Rezoning Transportation Analysis

Petition Number: 2022-145

Date	Description
1-25-23	First Review (IW)
2-22-23	Second Review (IW)

SHEET NUMBER
RZ-01

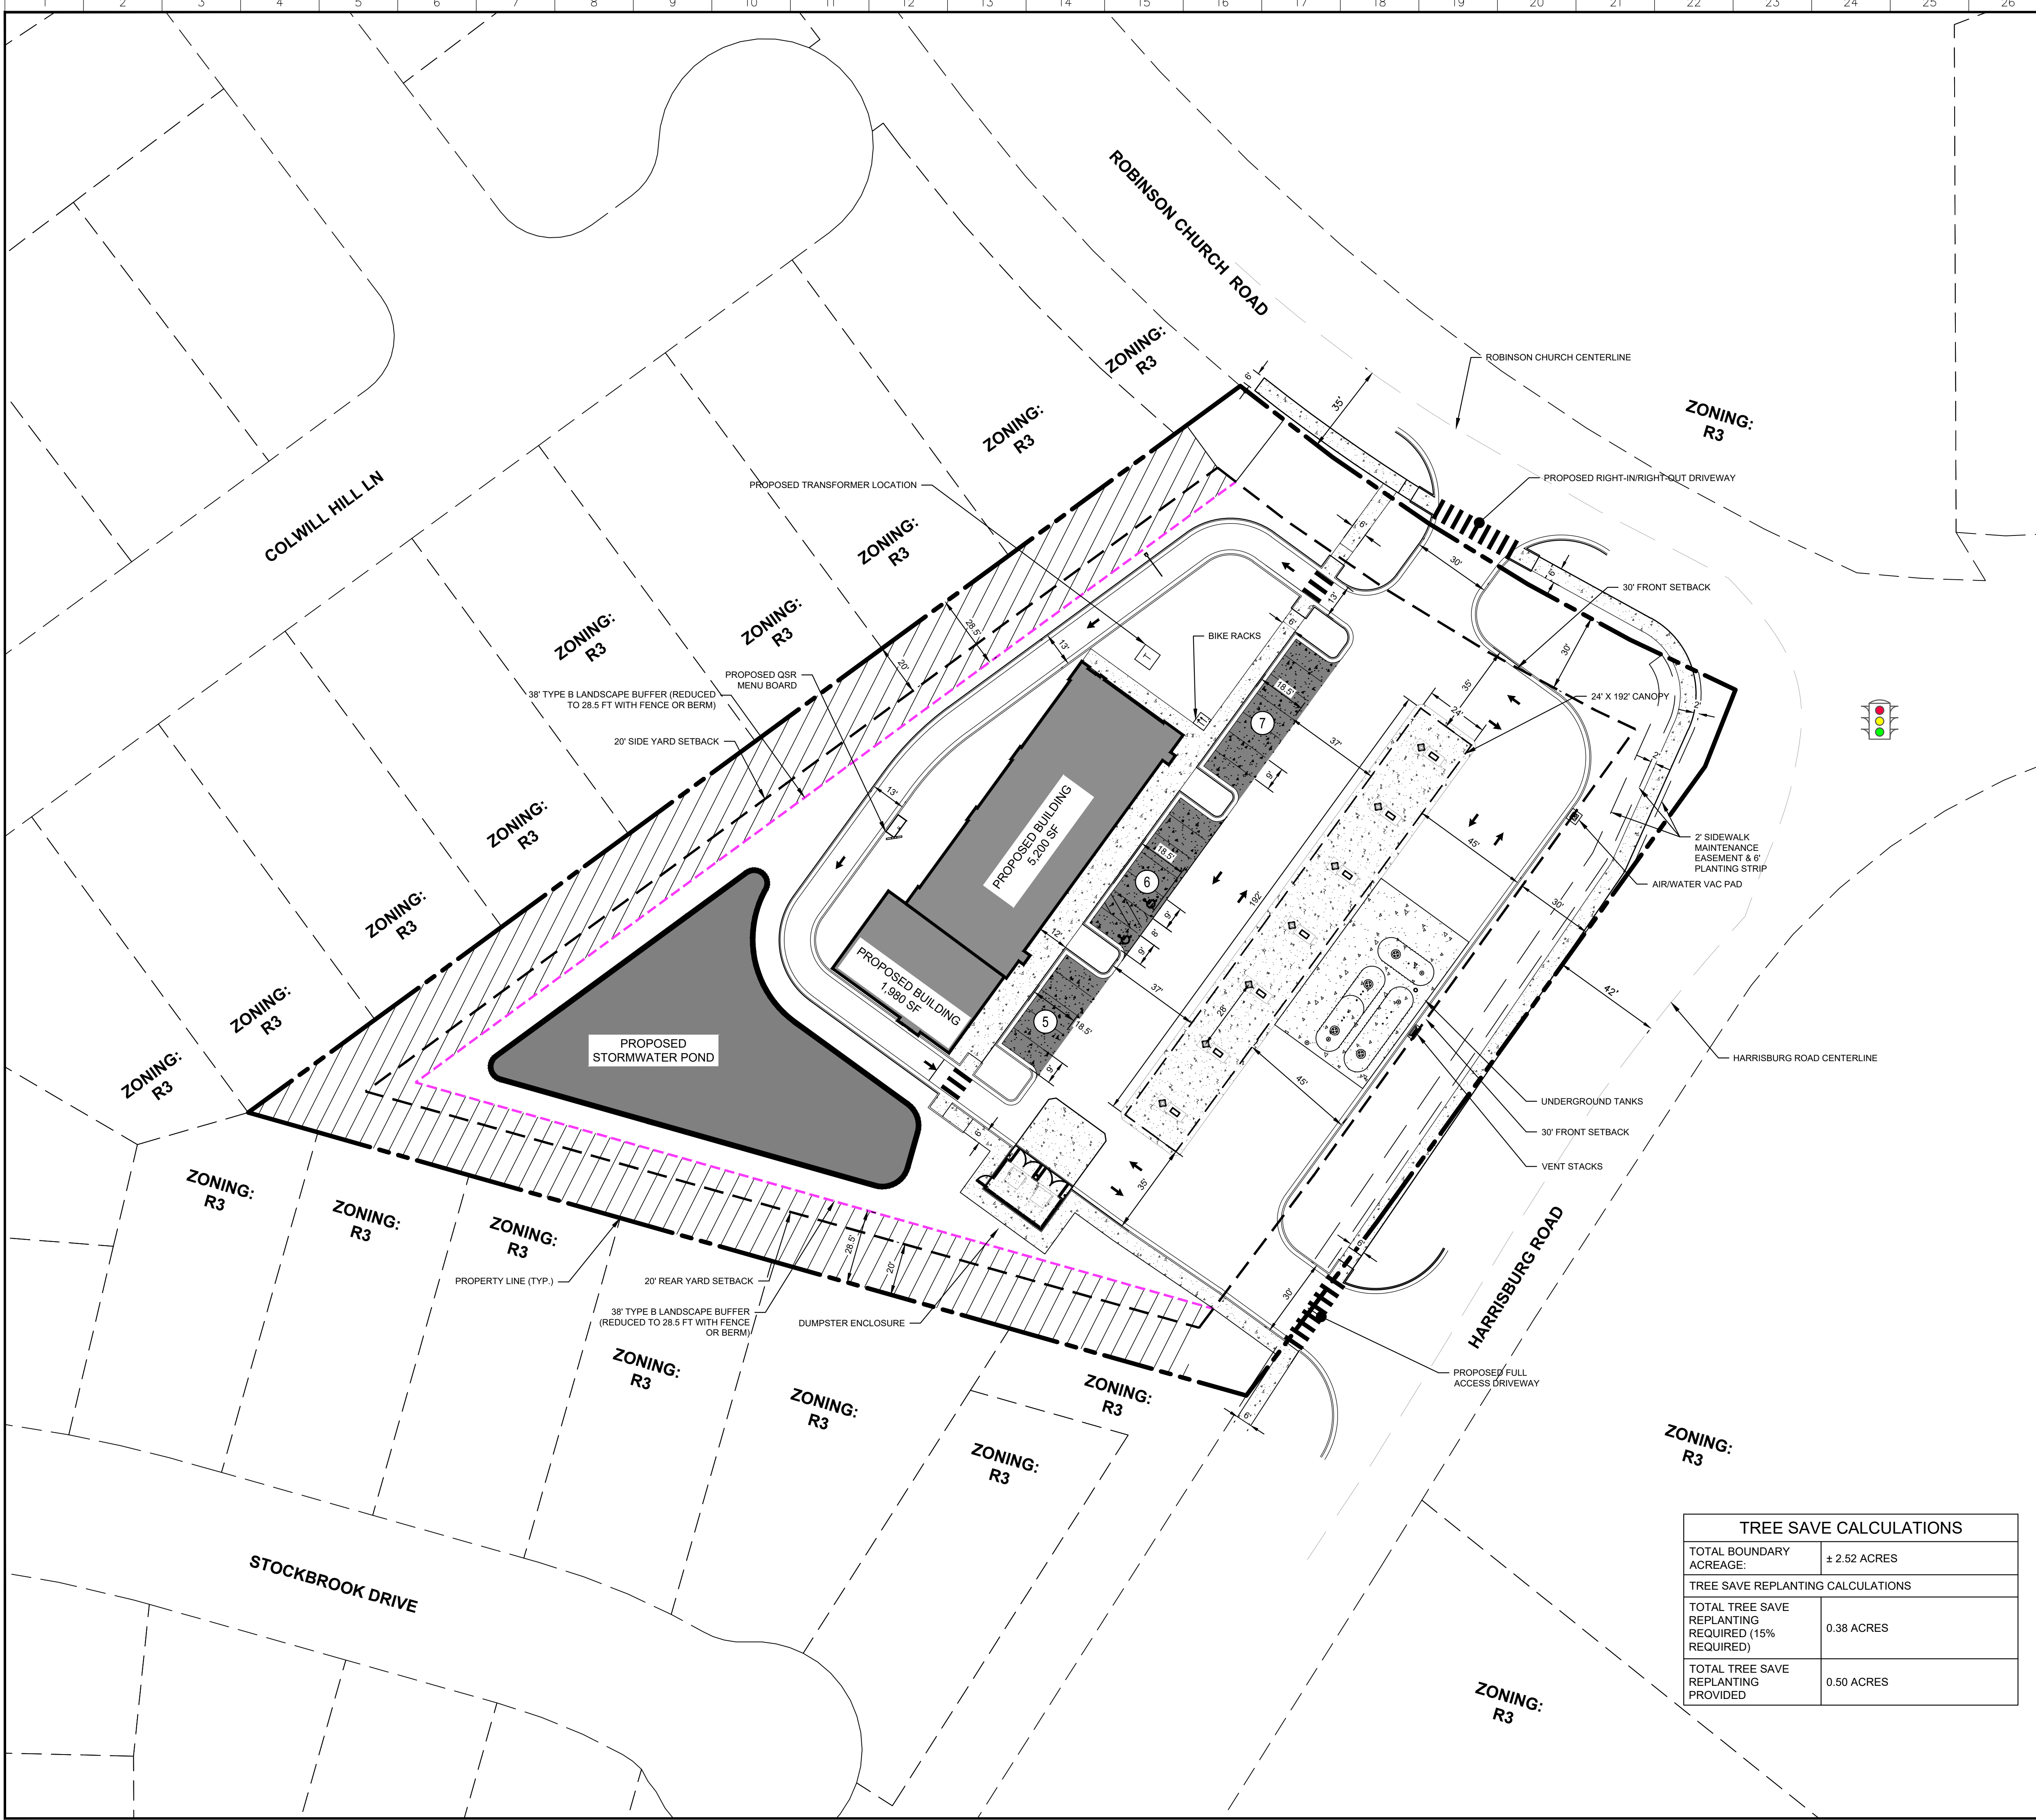
1. **Outstanding Comment from 1-25-23 Curblines:**

- a. **Robinson Church Road:** Location of future curb and gutter to be 19 feet from roadway centerline to accommodate the Charlotte Streets Map with a roadway typical section of CLDSM 11.09 Minor Thoroughfare.
- b. **Harrisburg Road:** Location of future curb and gutter to be 30 feet from roadway centerline to accommodate the Charlotte Streets Map with a roadway typical section of CLDSM 11.09 Major Thoroughfare.

Clarifying Comment 2-22-23: Site plan needs to be updated to show curb line and include the future back of curb dimensions described above.

Label and dimension the curb and gutter from the centerline for each road on the site plan.

3. **Outstanding Comment from 1-25-23** Revise site plan and conditional note(s) to commit to dedicate 41 feet of right-of-way from the Robinson Church Road centerline and 52 feet of right-of-way from the Harrisburg Road centerline. The site plan shall label and dimension the right-of-way from the road centerline.

7. **Outstanding Comment from 1-25-23** Revise site plan to move driveway on Robinson Church Road as close to property line as possible to create more space from the existing signalized intersection per coordination with NCDOT.

Clarifying Comment 2-22-23: Site plan should show driveway on Robinson Church road to be moved as far from the Harrisburg Road intersection as possible.
